3A10/1003SW (D13/102536)

MP09_0088

3 May 2013

**Shoalhaven Water Response – Exhibition of Environmental Assessment
for Concept Approval – Mixed Use Subdivision, West Culburra
(MP09_0088)**

RESIDENTIAL STAGE ONE

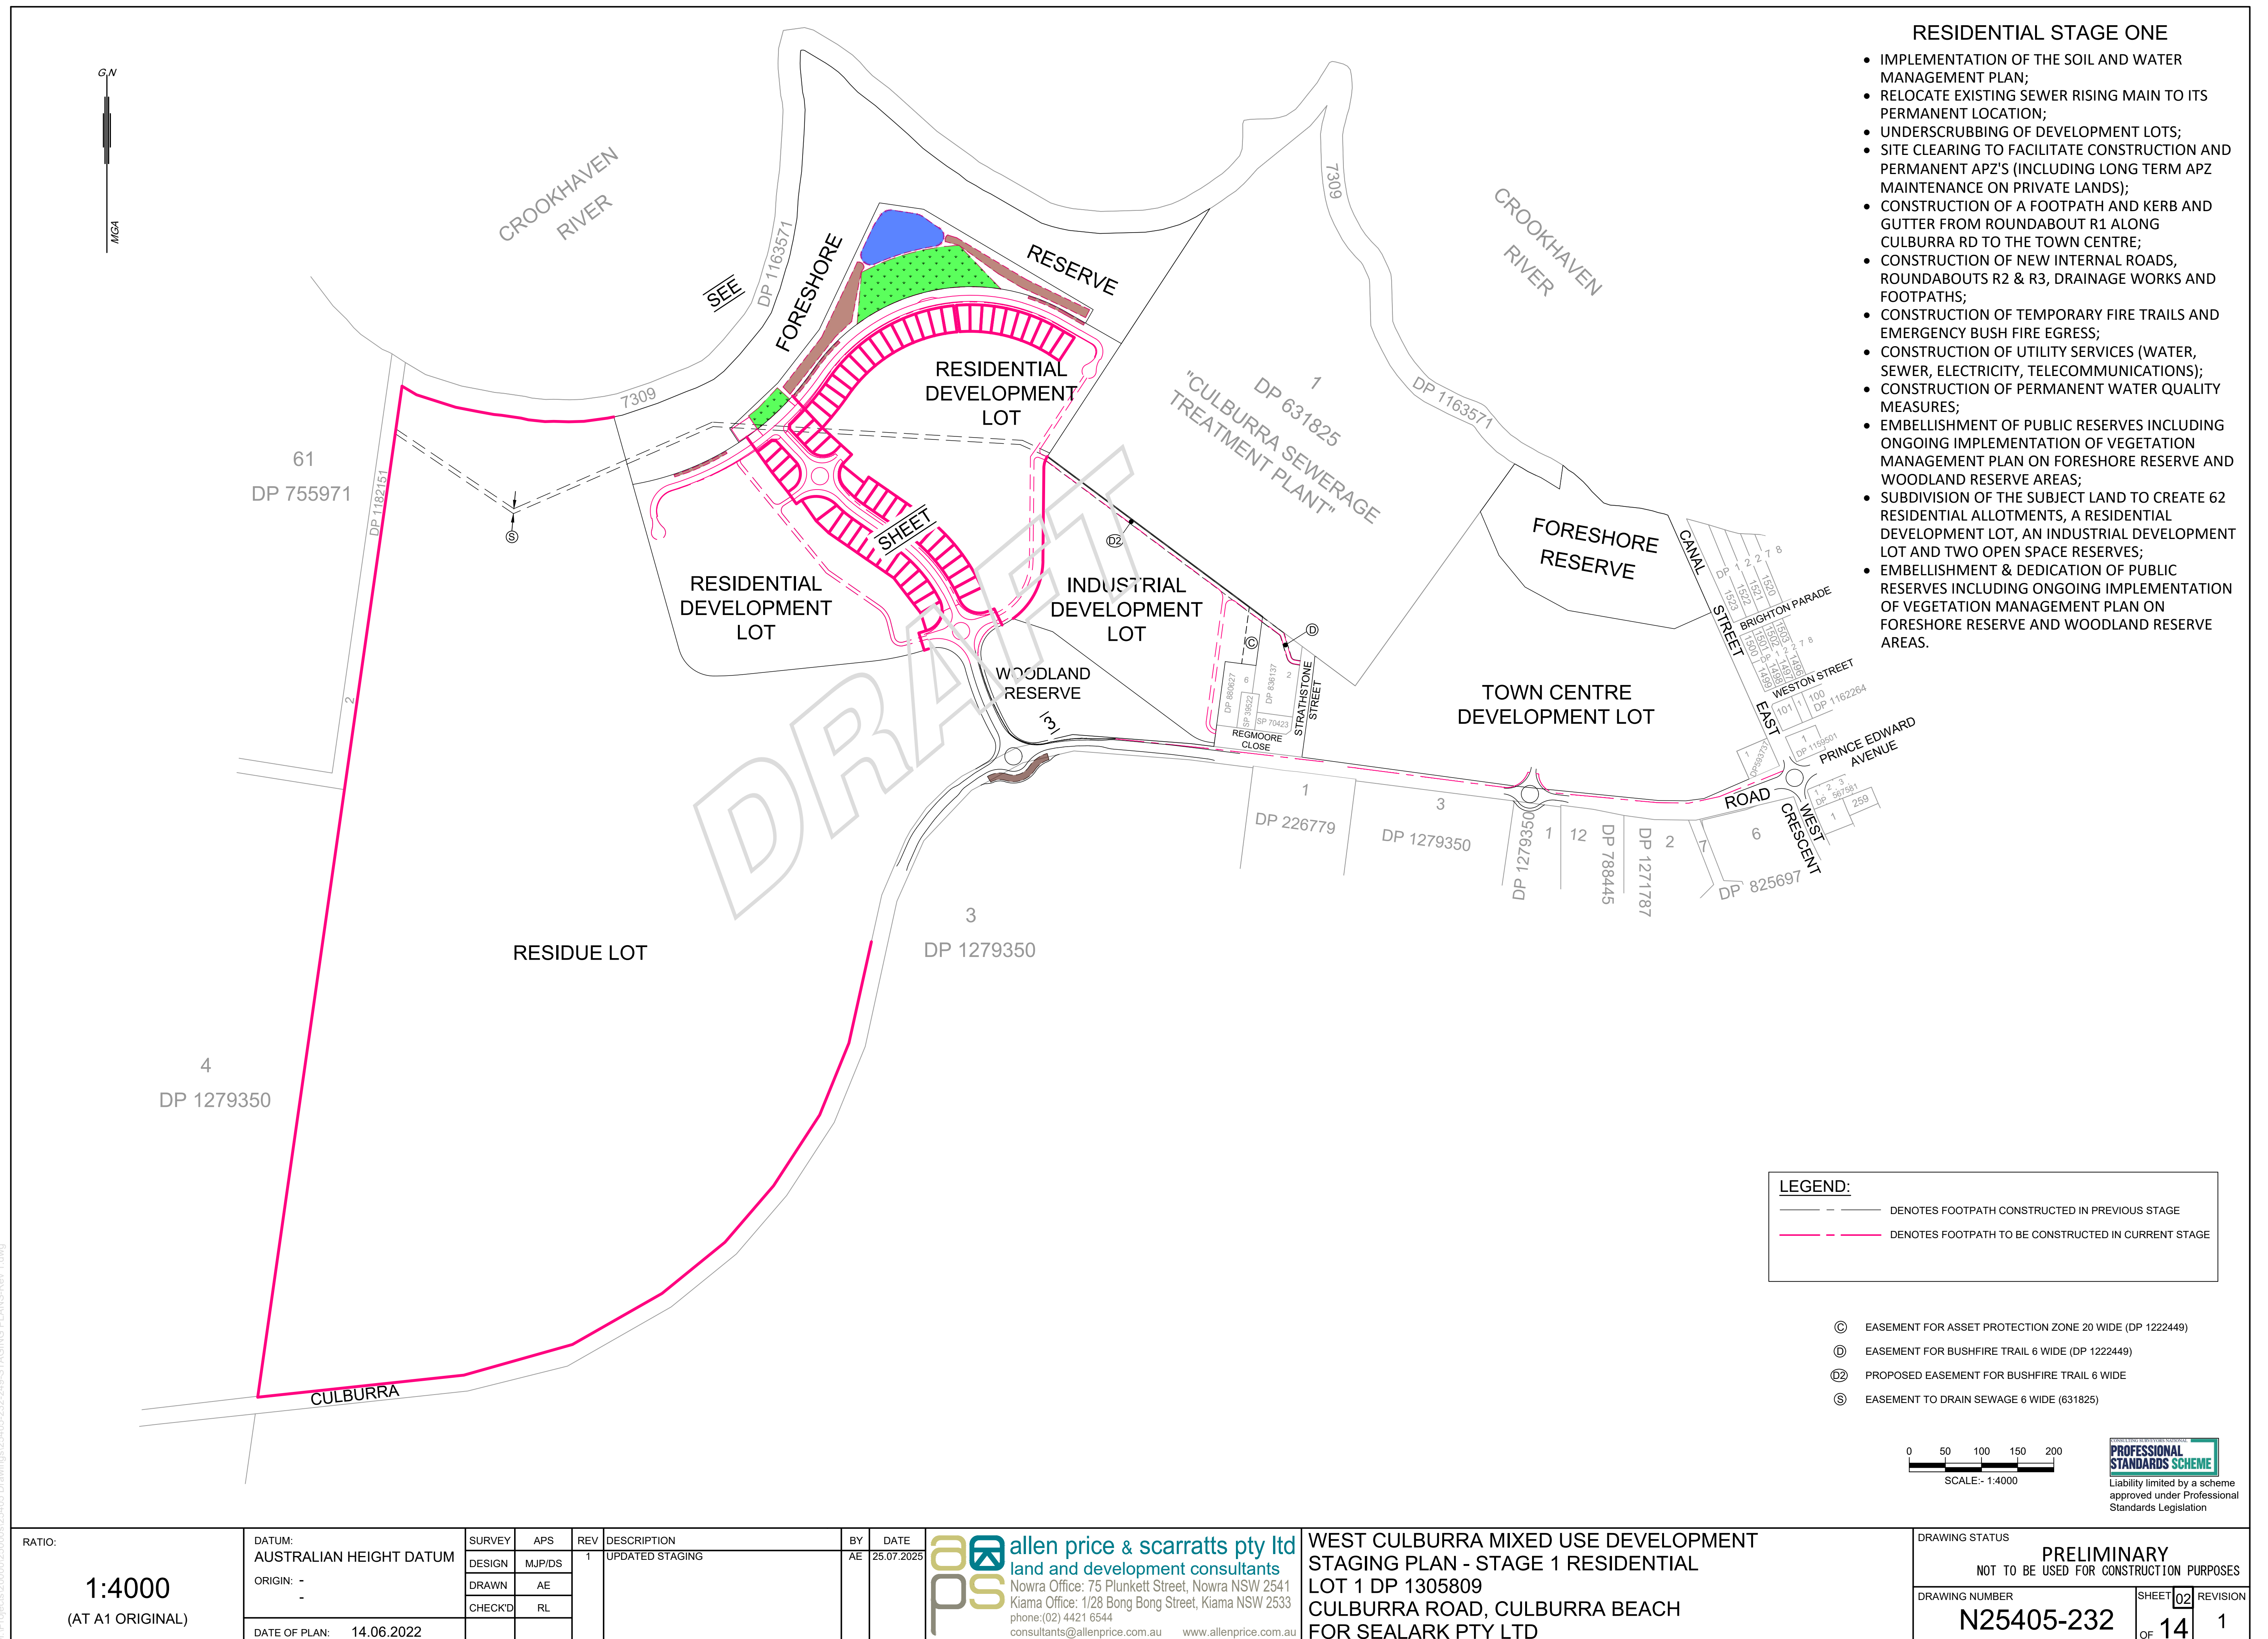
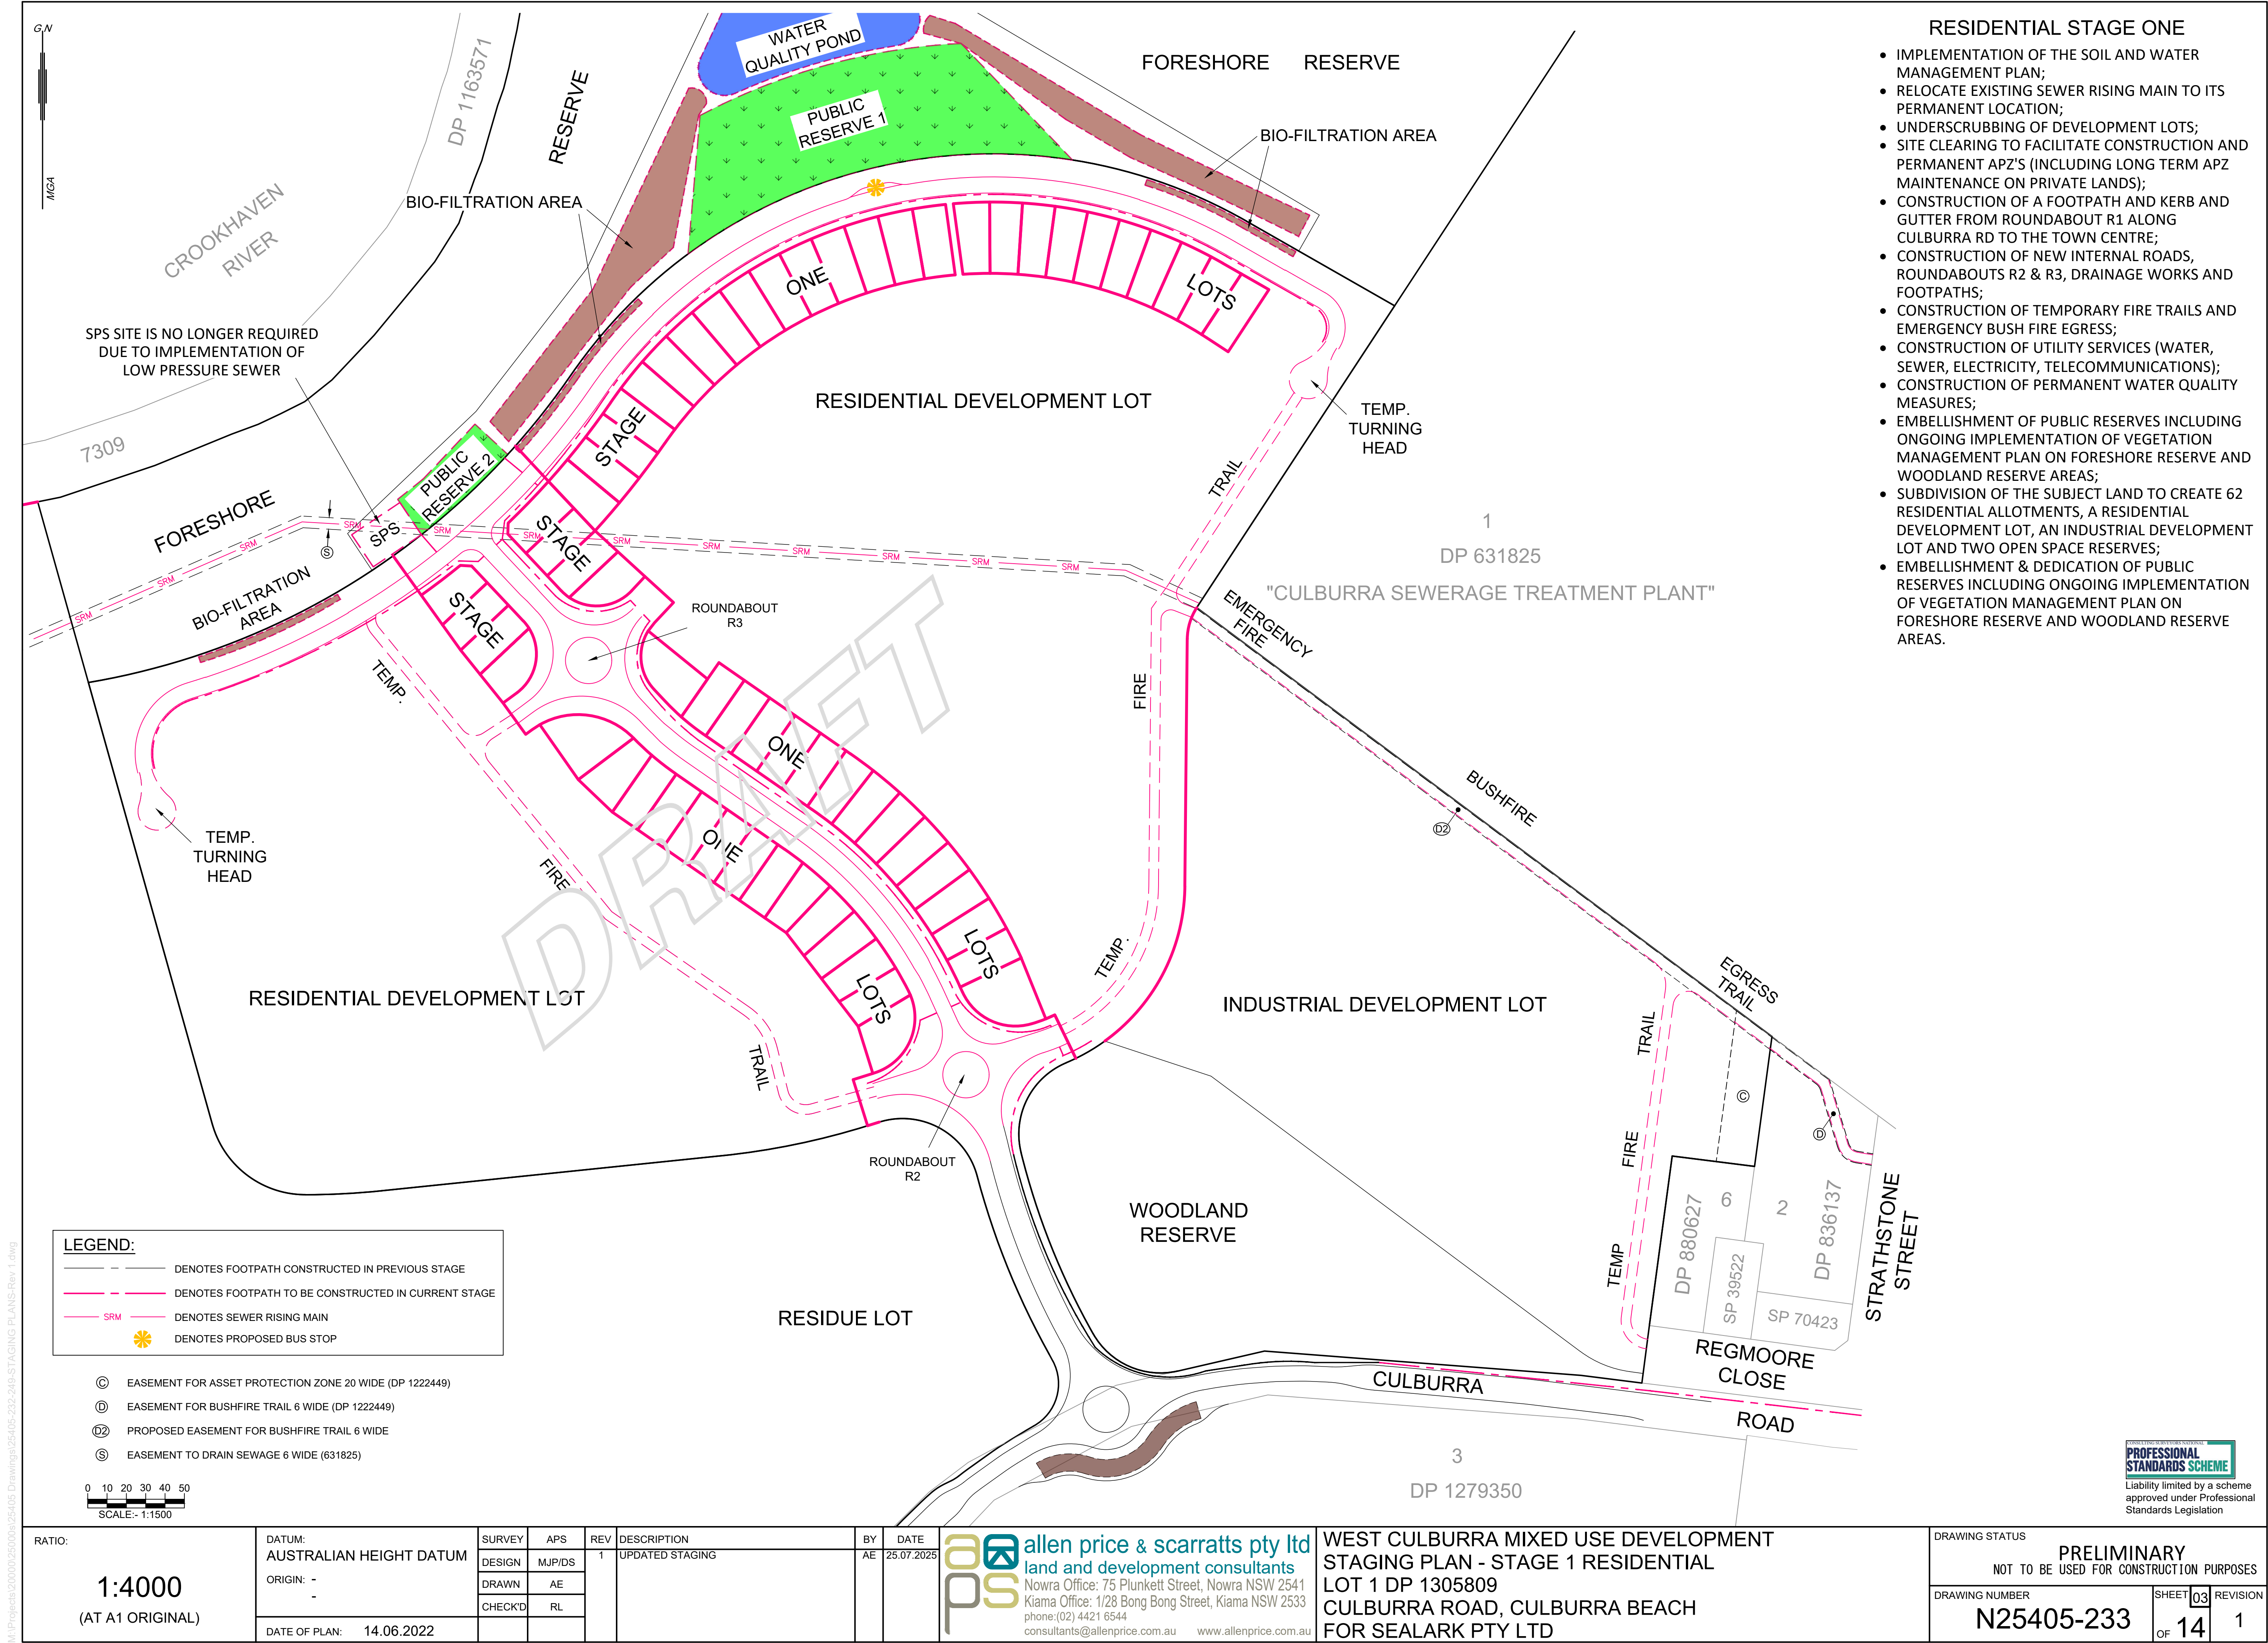
- An existing 225mm DICL & 375mm DICL sewer rising main (SRM) is located within an easement within lot 6 DP 1065111, Shoalhaven Water will not permit the construction of any structure within the boundary of the

easement or within the zone of influence of the existing pipe. The applicant shall consider the location of the existing 225mm SRM and easement during design. Any proposed relocation of this main shall be determined after detailed consultation with Shoalhaven Water.
